OUT20/10366

**Prospect Logistics Estate (SSD-10399)
EIS**

Simon Francis
Senior Project Officer, Assessments
Water – Strategic Relations
12 October 2020

LONG SECTION - PIT 7 TO WETLAND
SCALE 1:500 HORIZONTAL
1:100 VERTICAL

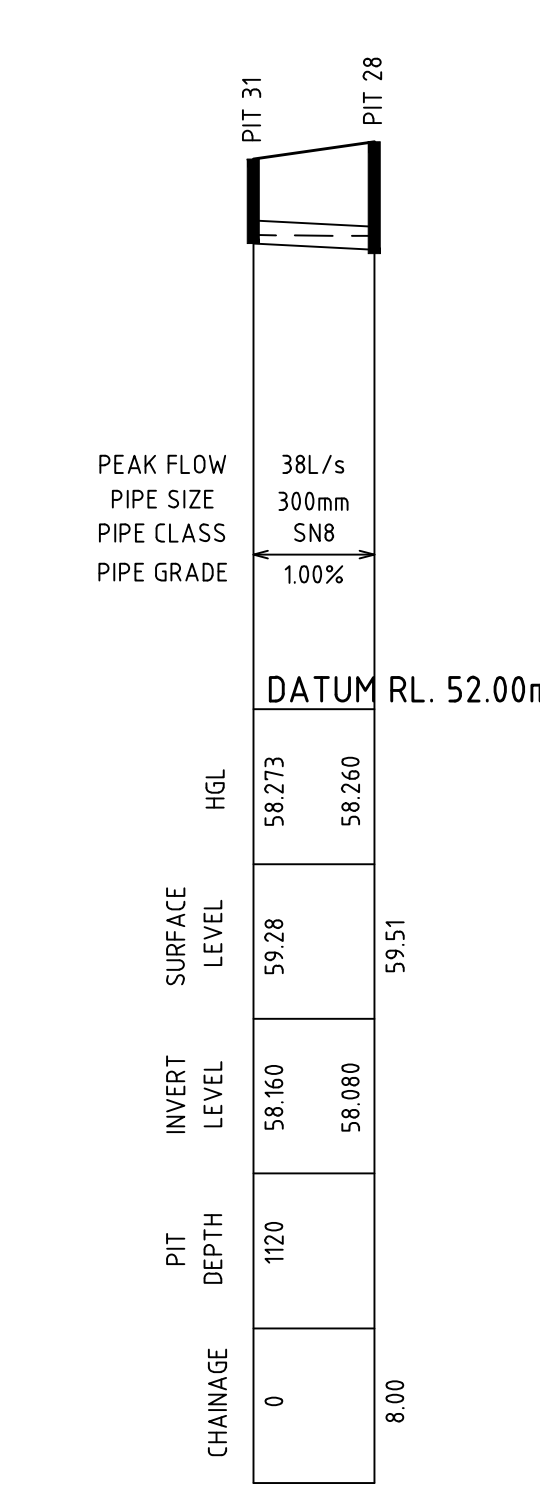
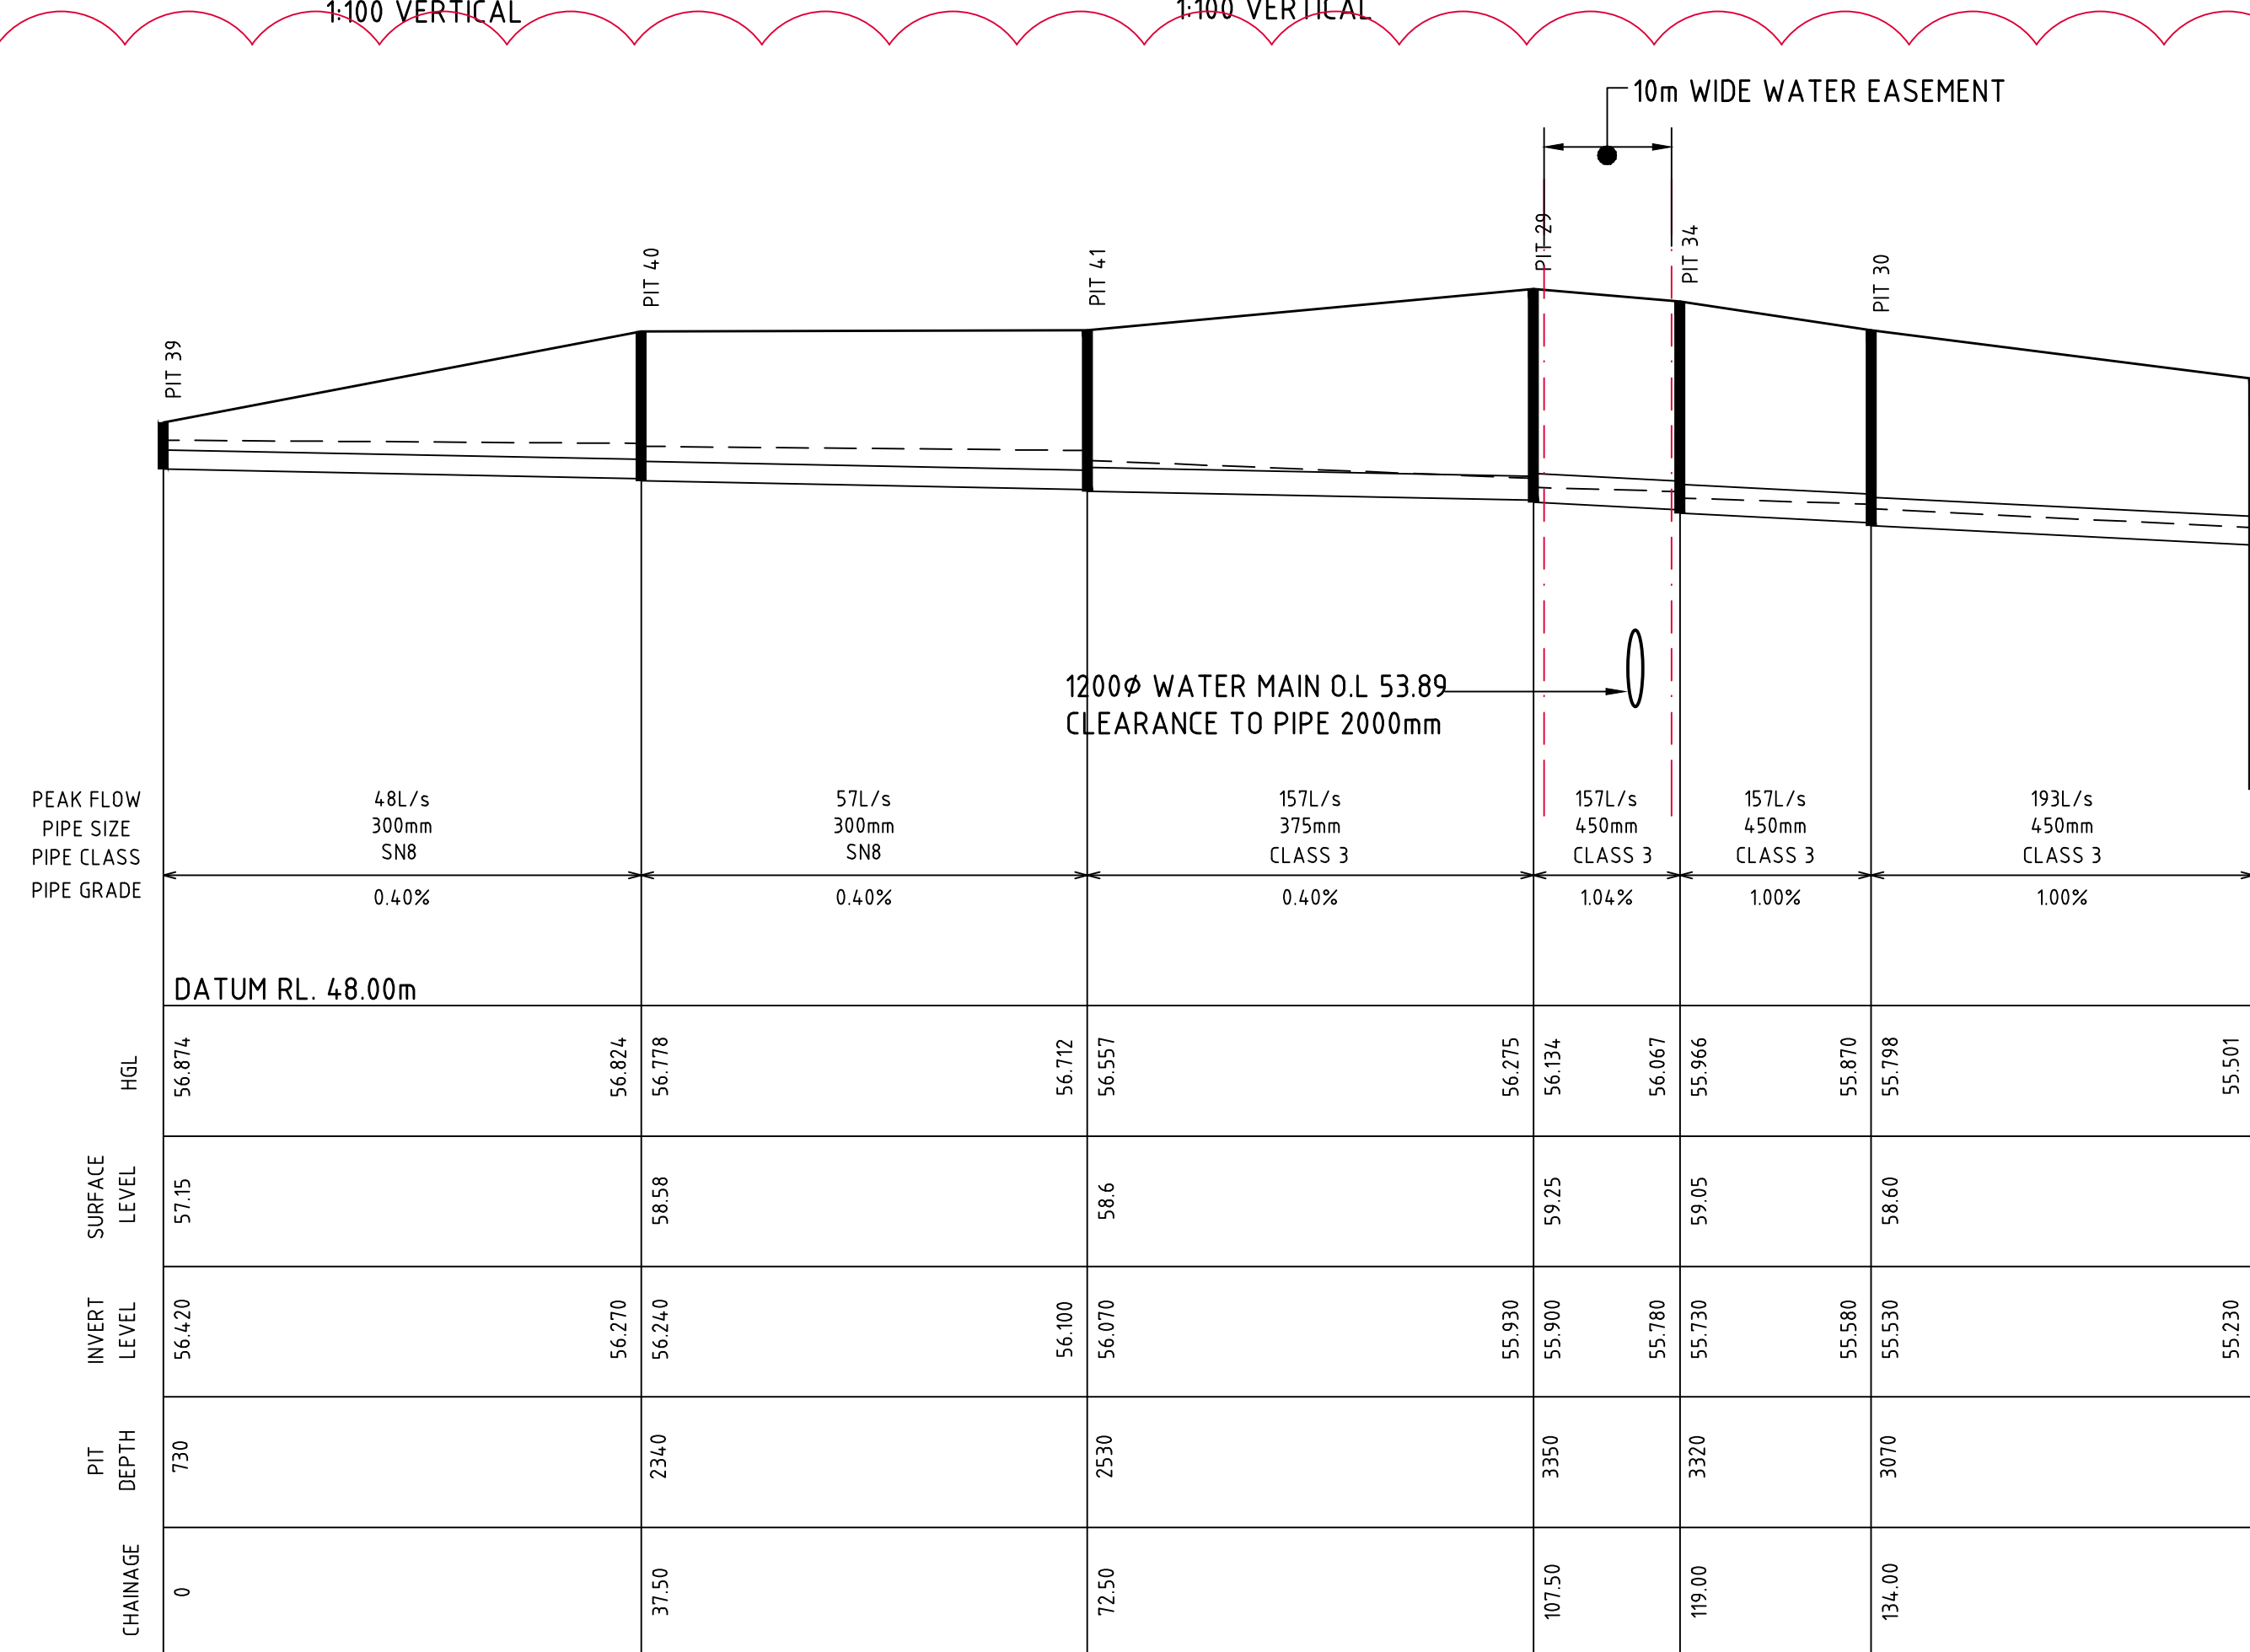
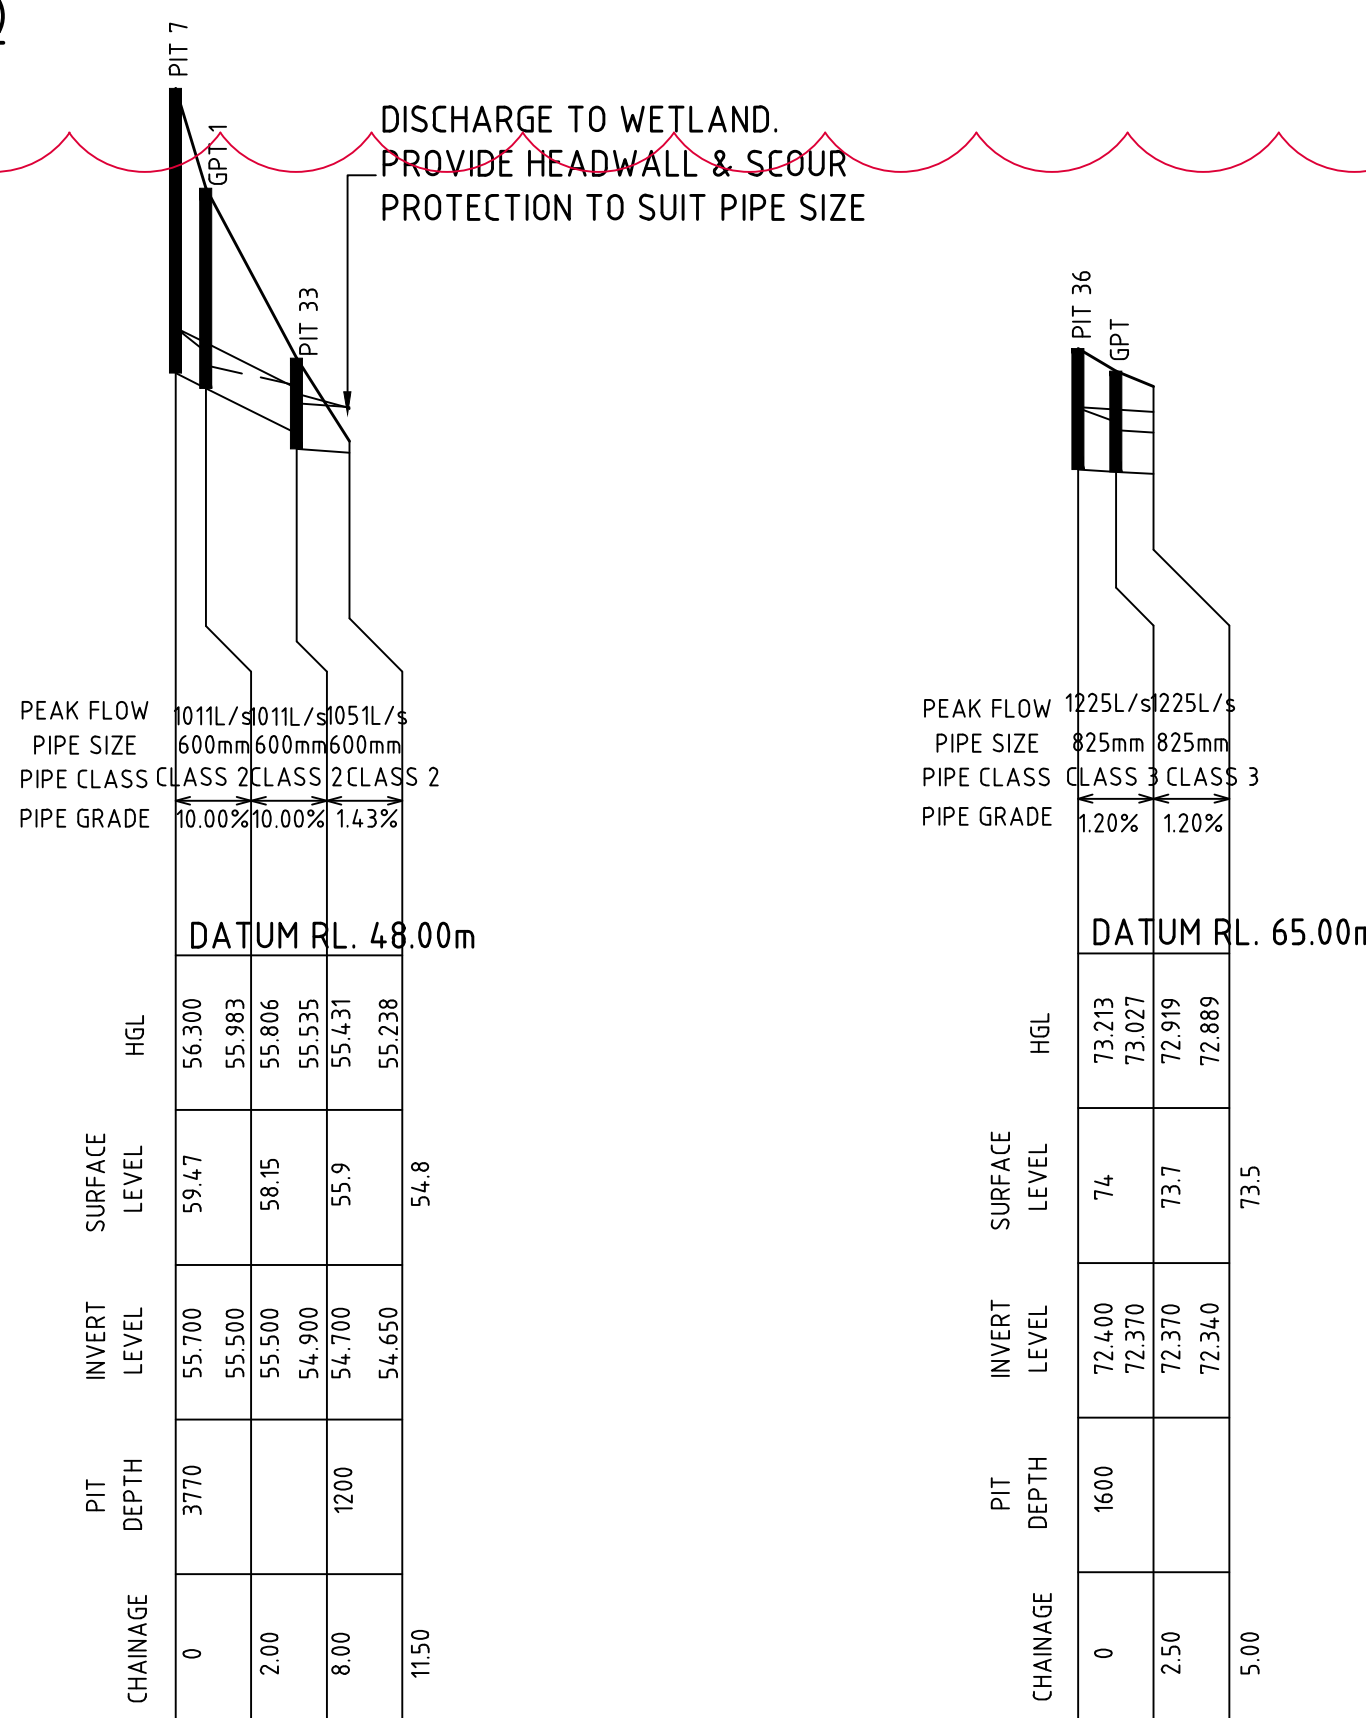
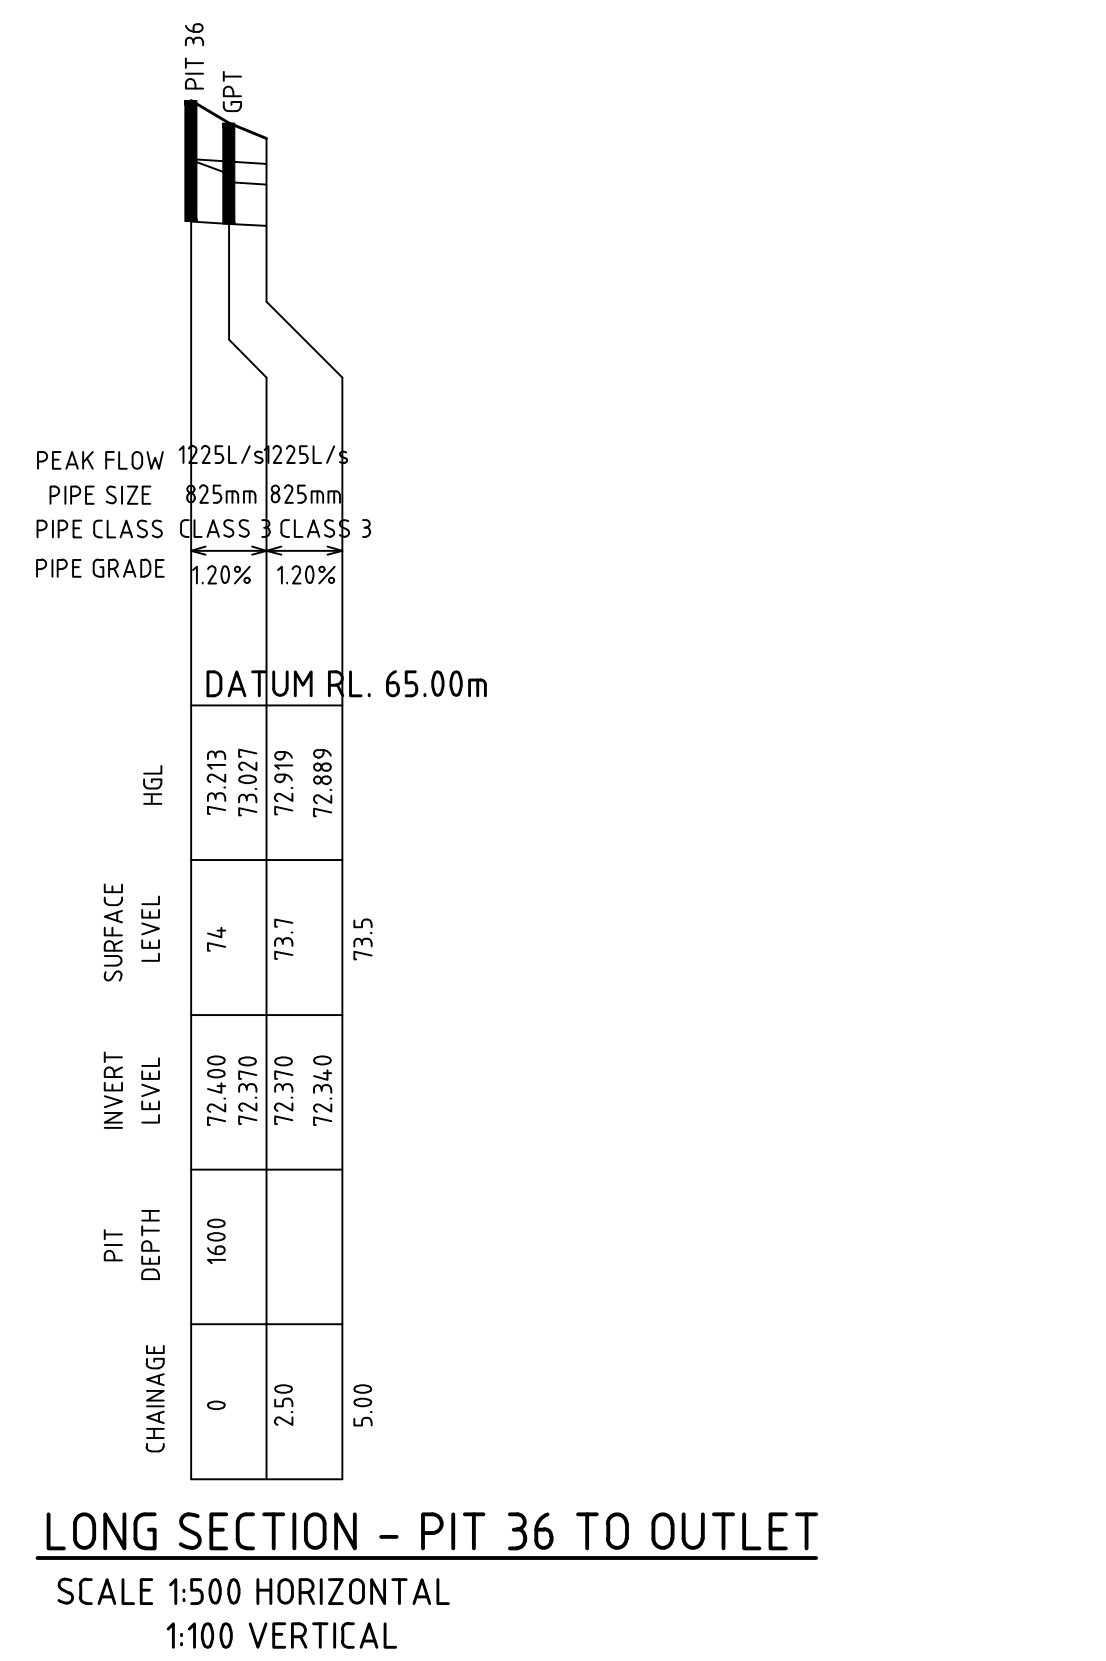
- The development proposal includes stormwater management works in the northern section of the site which contains a wetland and 2nd order watercourse. The EIS doesn't show any consideration of the NRAR Guidelines for Controlled Activities on waterfront land (NRAR, 2018) in relation to this waterfront land. The proponent should provide detail on how the development proposal has shown due consideration to the NRAR Guidelines. The guideline is found here:
https://www.industry.nsw.gov.au/_data/assets/pdf_file/0004/156865/NRAR-Guidelines-for-controlled-activities-on-waterfront-land-Riparian-corridors.pdf
